CITY OF PORTLAND, MAINE

September 17, 2018

Project Name: MMC Employee Garage
Project ID: 000207-2018
Address: 190 St. John Street, Portland
CBLs: 64-A-2, 64-A-8, 64-A-9, 64-A-11, 75-A-6, 74-A-7, 68-D-13, 68-D-14, 68-D-16, with off-site improvements at 64-A-1 and 68-D-3 and in the public right-of-way
Applicant: Maine Medical Center
Planner: Nell Donaldson

Drawing file: Plans / 8_C-104_Utility Plan - 1.pdf

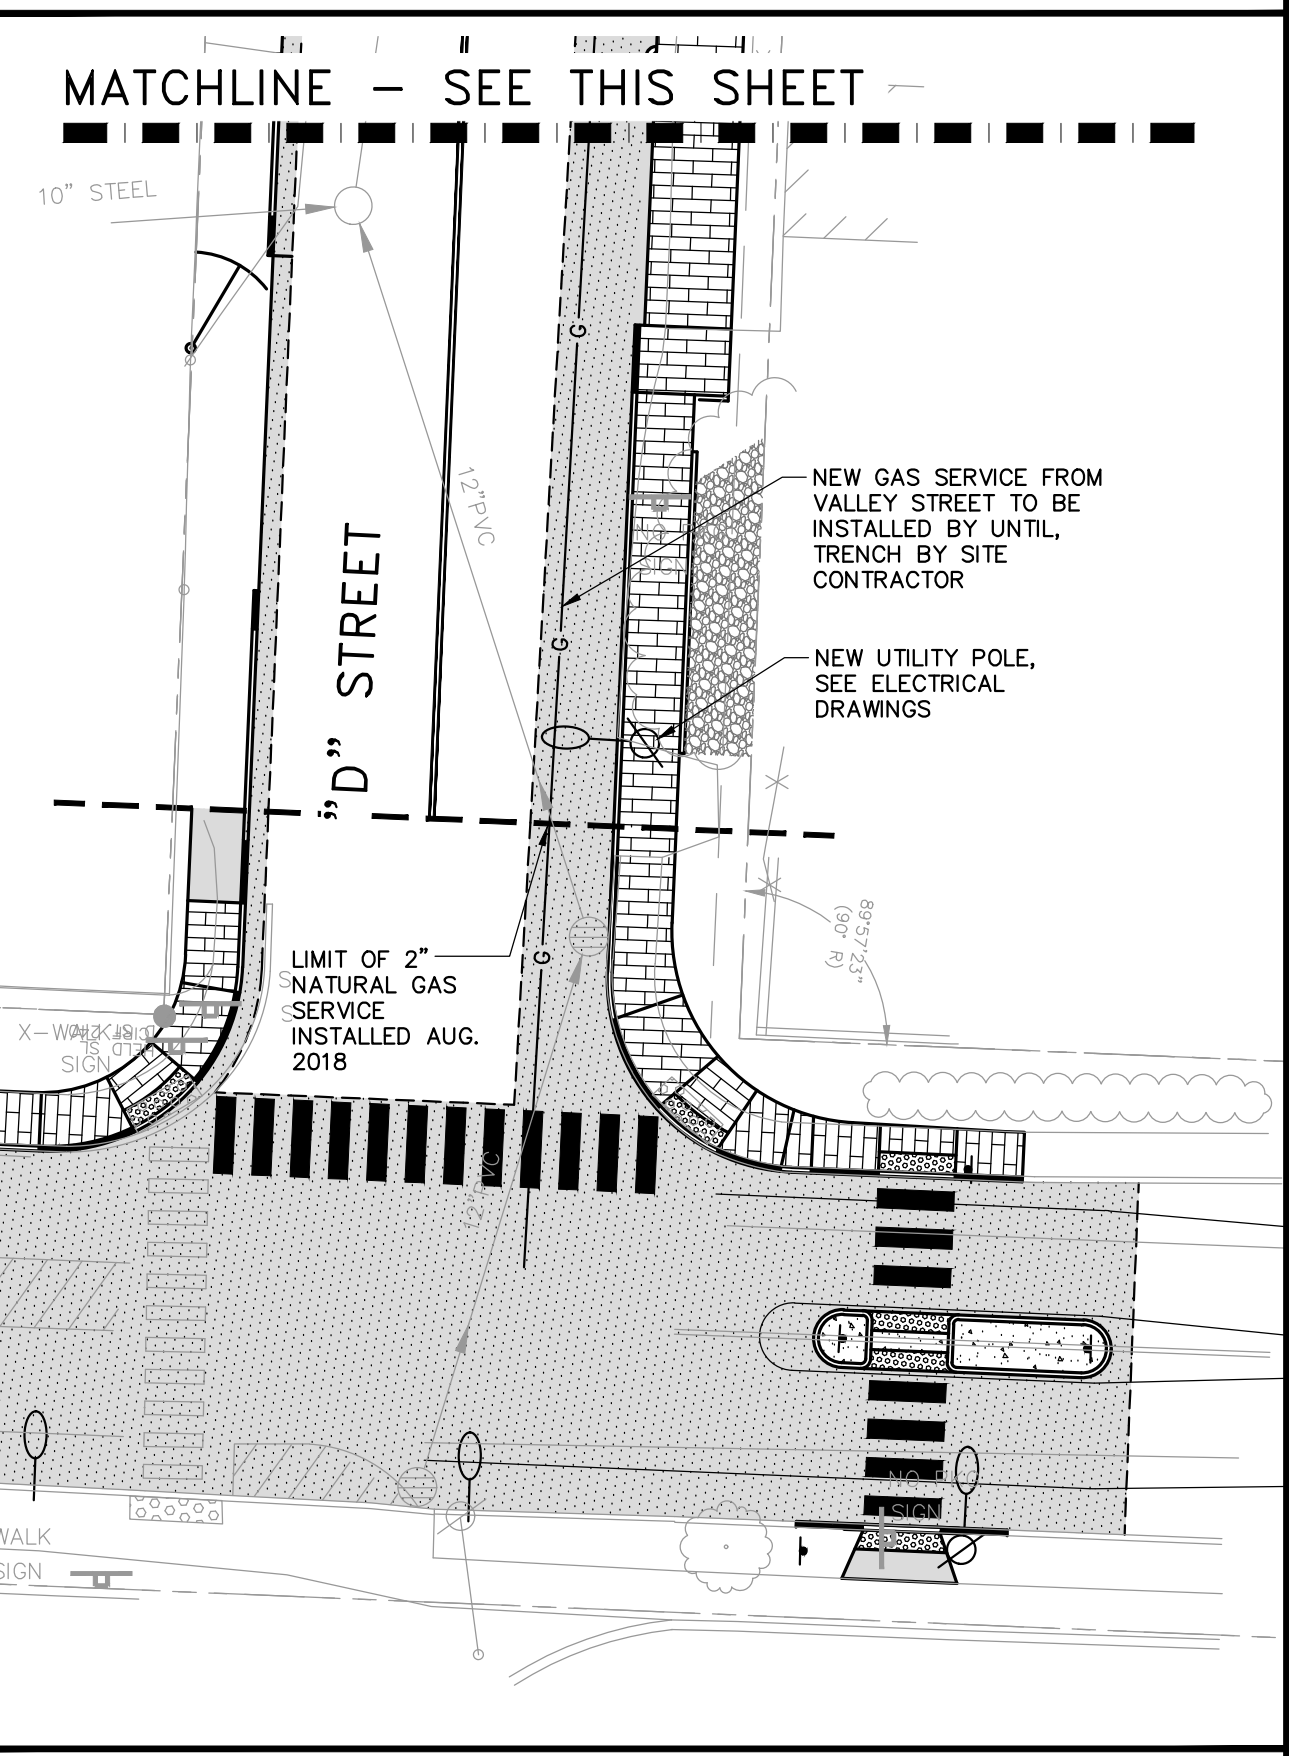
- vi. Revised utility pole placement consistent with C-104 Utility plan
